Your ref:
Our ref: 22/00721/F
Please ask for: Mrs Joanne Rahman
Direct dial: 01553 616233
E-mail: borough.planning@west-norfolk.gov.uk

10 May 2022

Details: **Alteration and two storey extension to semi-detached dwelling at Quorn 24
Popes Lane Terrington St Clement King's Lynn Norfolk**

BLOCK PLAN  
1:500

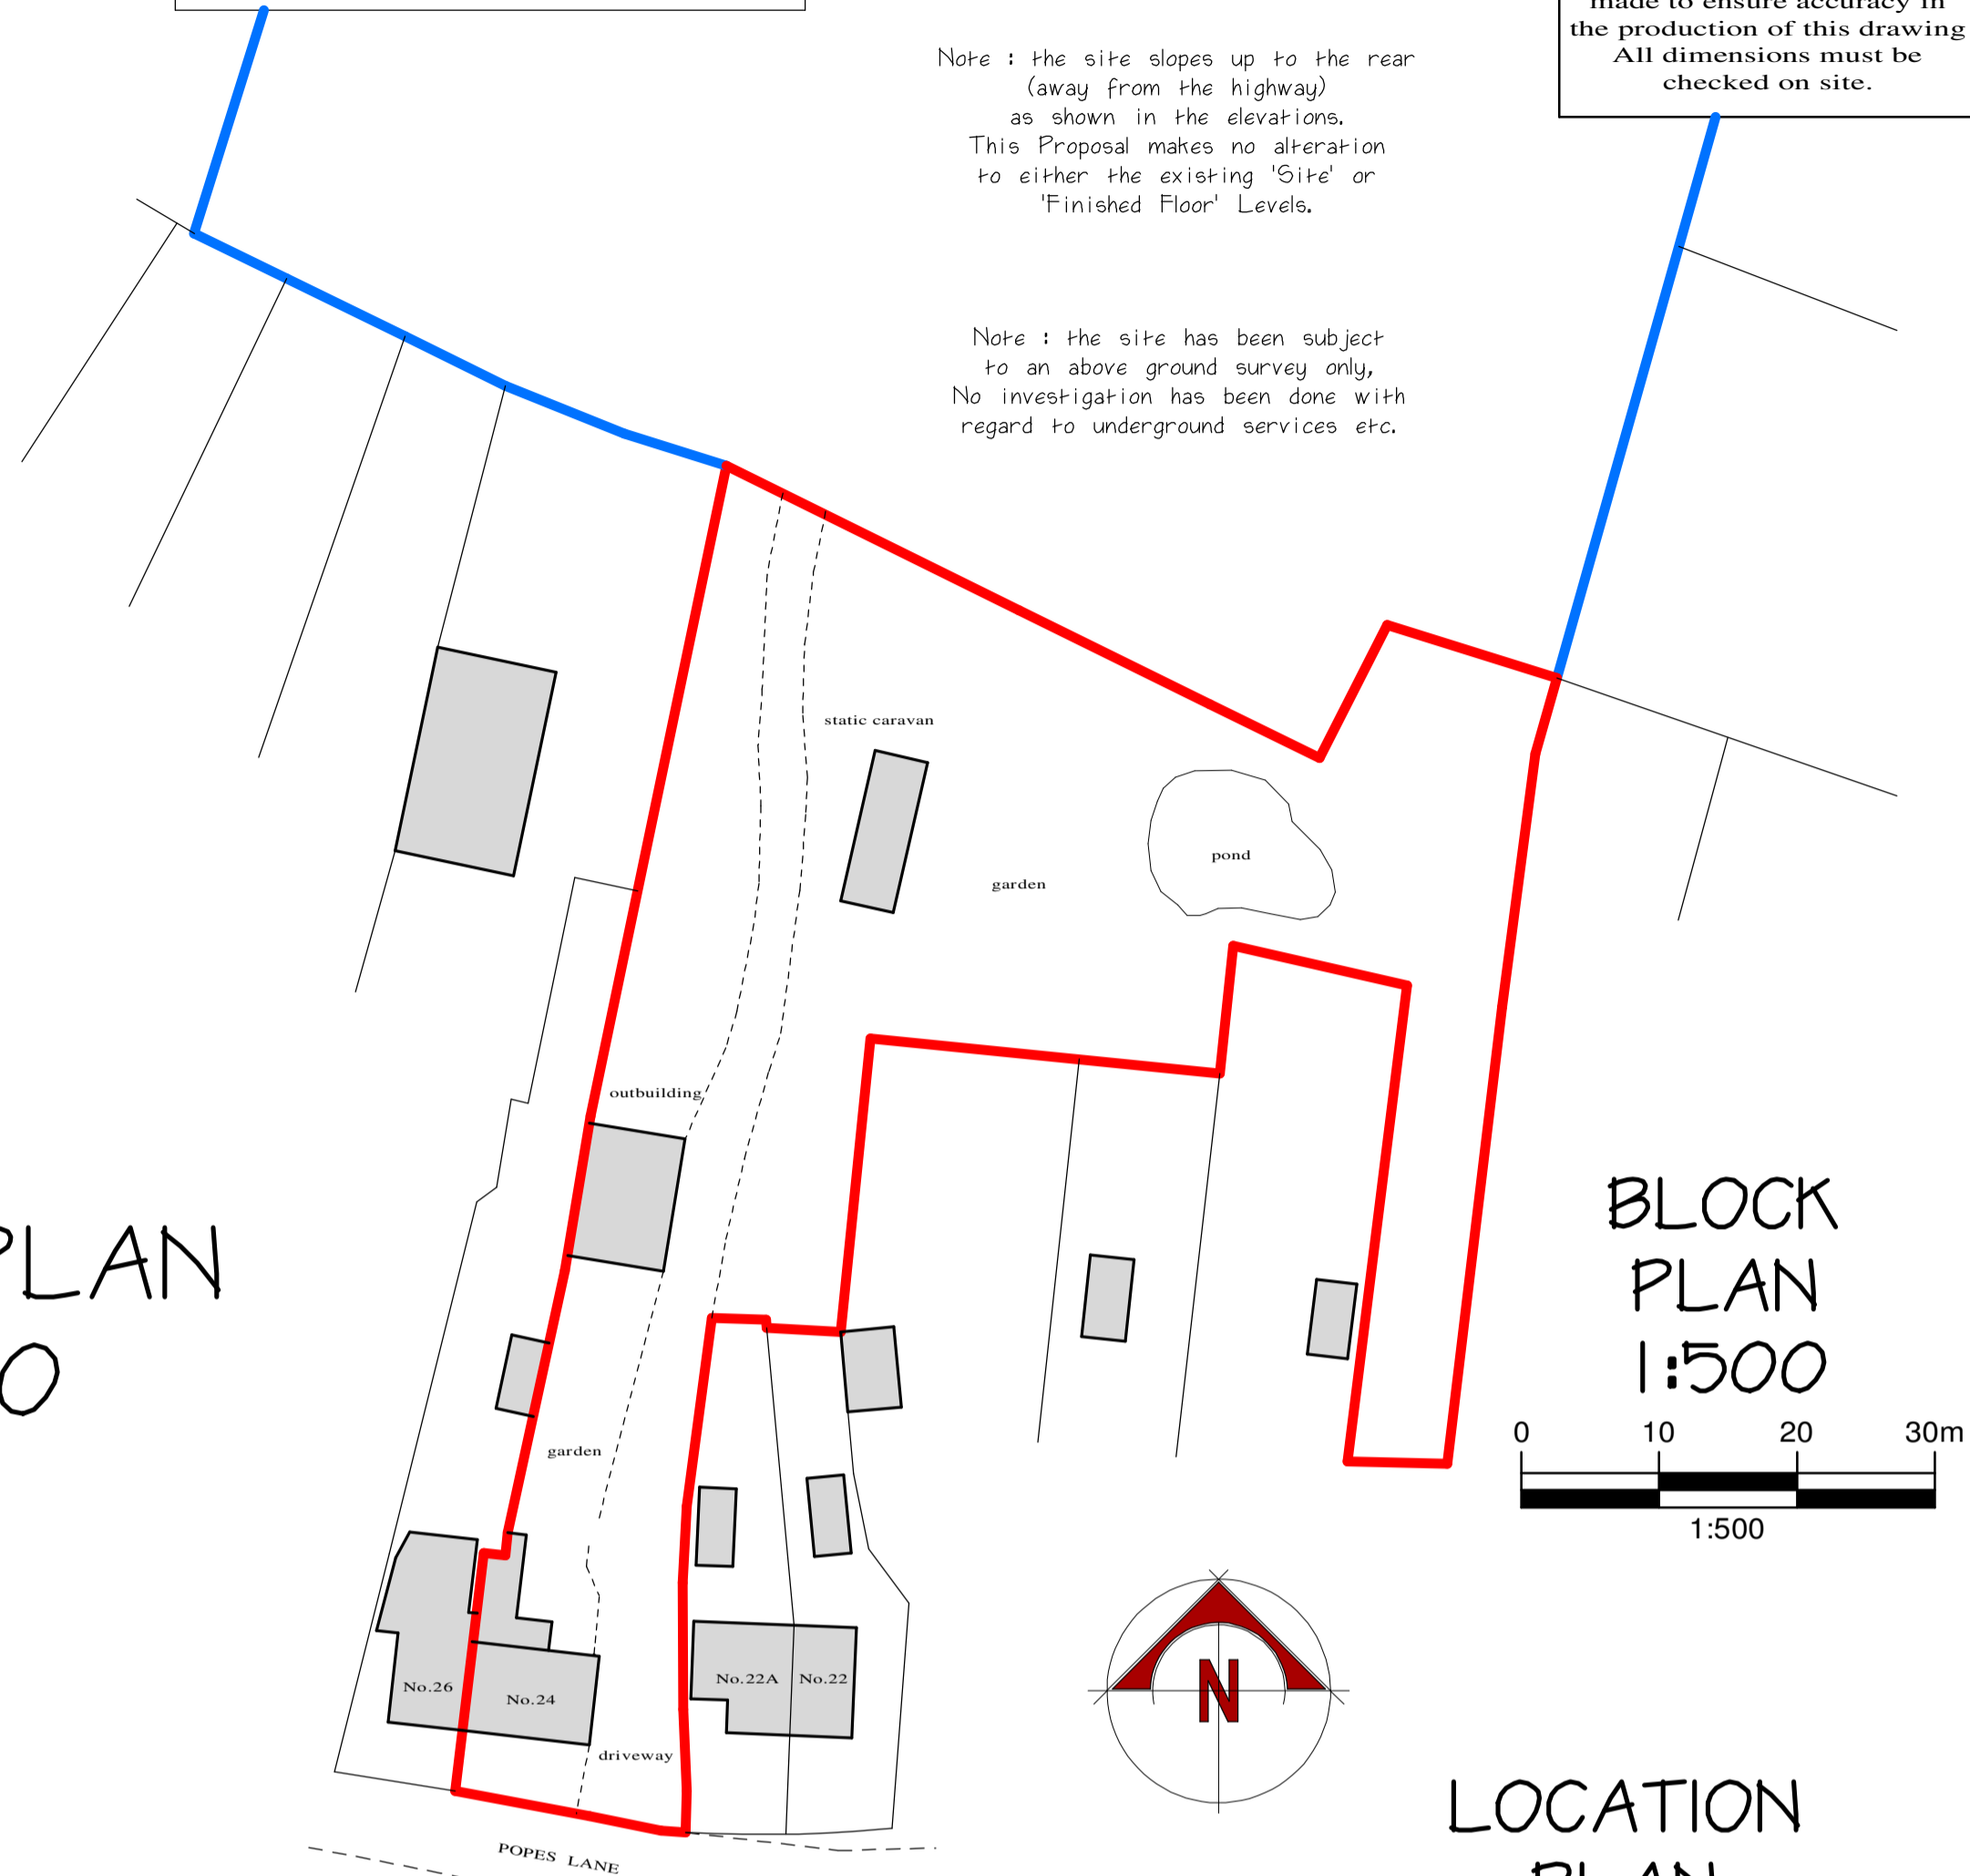
1. It would appear that the red line on your location and block plans edges land outside of the curtilage of the dwelling. Please submit location and block plans with the red line edging the curtilage of the dwelling.
2. I note that you have signed ownership certificate B, stating that some of the land relates to part of an agricultural holding. Please check that you have edged the curtilage of the dwelling only and have signed the correct ownership certificate.
